Ribble Valley Borough Council

DELEGATED ITEM FILE REPORT - APPROVAL

Application No:	3/2015/0276/P
Development Proposed:	Discharge of conditions, revised footways and parking bays, walling and roofing, landscaping and renewable energy in relation to consent 3/2009/0399 at land adjacent 34 Kirklands, Chipping

Client:	KEEPMOAT		
Job:	KIRKLANDS, CHIPPING		
Drawing title:	SITE LAYOUT		
Drawing Number: (Job number)	M3792	100	Revision: E
Scale:	1:100@A1		
Date:	FEB 15		
Drawn by/ checked by:	MCS

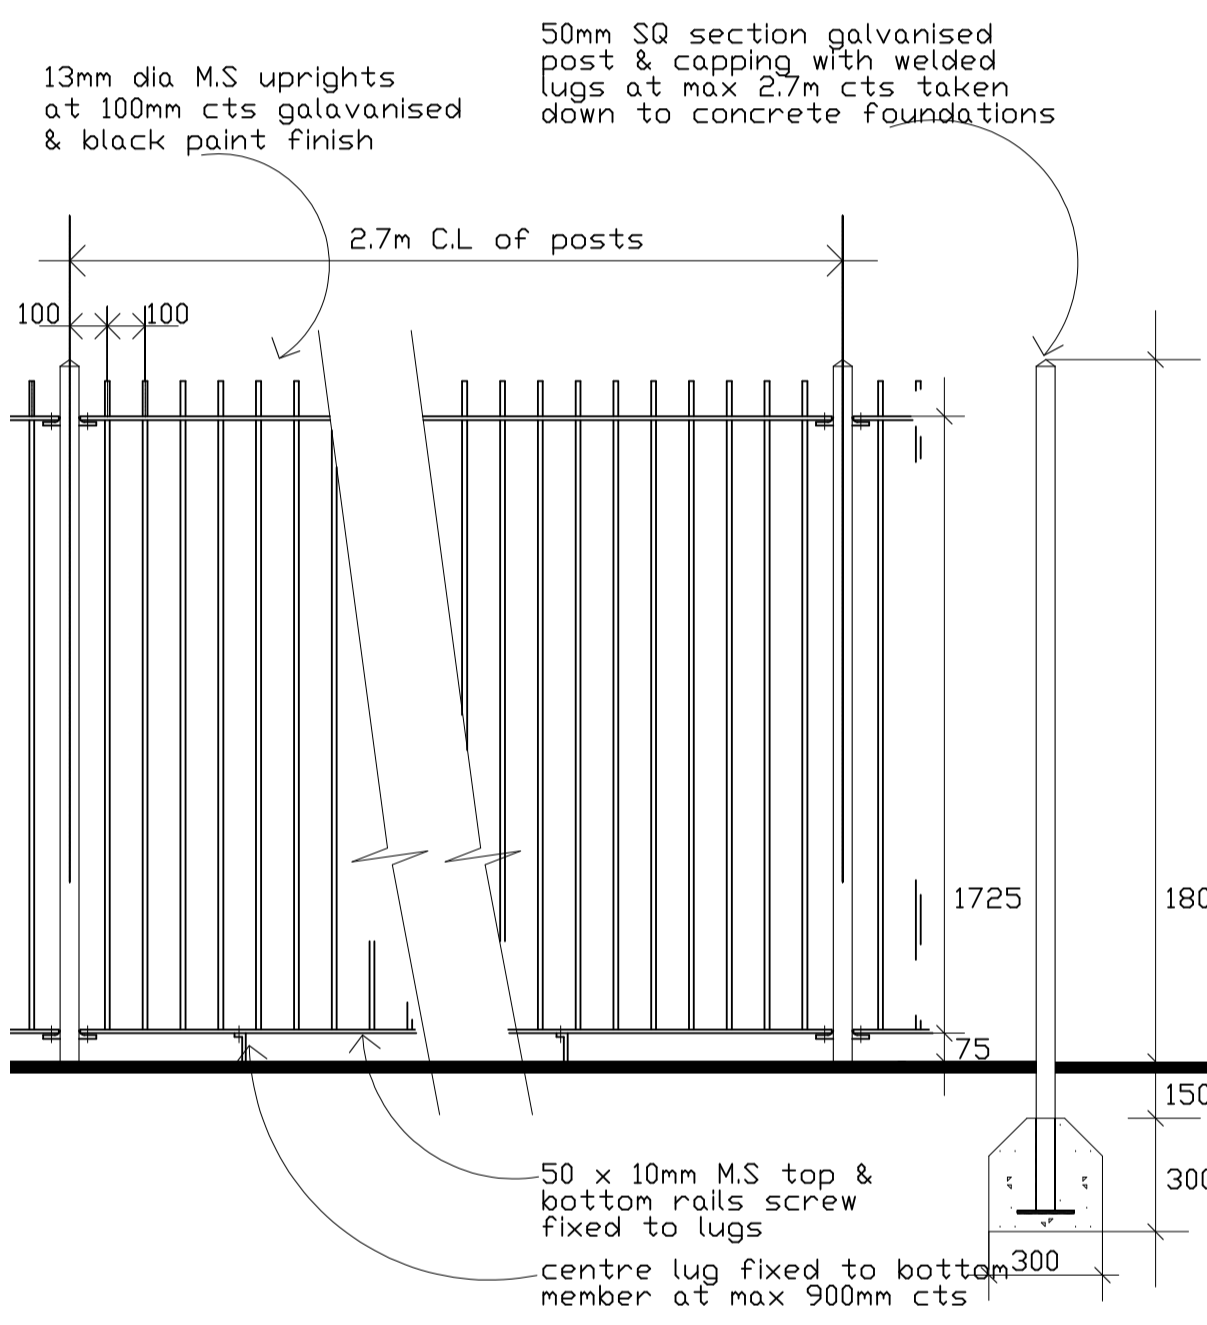
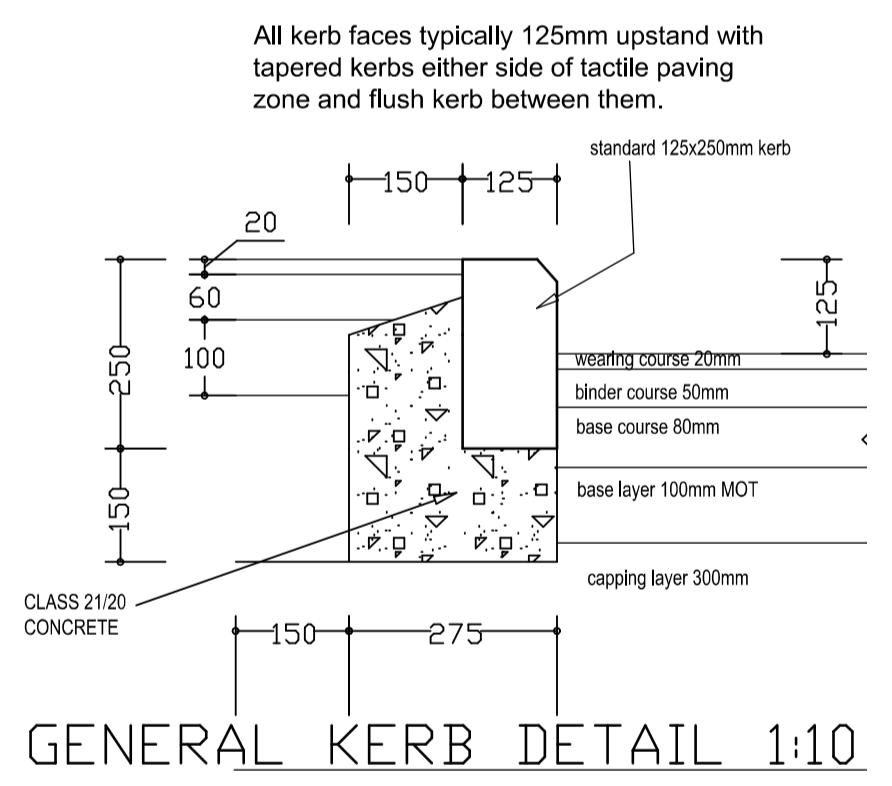
Environment Directorate (County Surveyor) – Following revised plans, still consider there are further alterations necessary to ensure highway safety. .

This application seeks to discharge various planning conditions in relation to a residential development scheme at land adjacent to 34 Kirklands, Chipping. In relation to walling and roofing materials and landscaping, I am satisfied that the proposed materials are acceptable in this instance. The site is fairly compact and there are some existing buildings as part of this overall scheme which have been completed and the proposed materials including heads and sills are similar to that already built. Further details have been submitted regarding renewable energy and the additional plan shows details of solar panels on the rear elevation and gable elevation. Although these will be fairly prominent within the Conservation Area, I consider them to be acceptable. In relation to highway matters, the plan has been amended to comply with the County Surveyor's comments but it is clear there is need for a further revision. On the basis of a subsequent amended plan, I am satisfied that the conditions can be discharged.
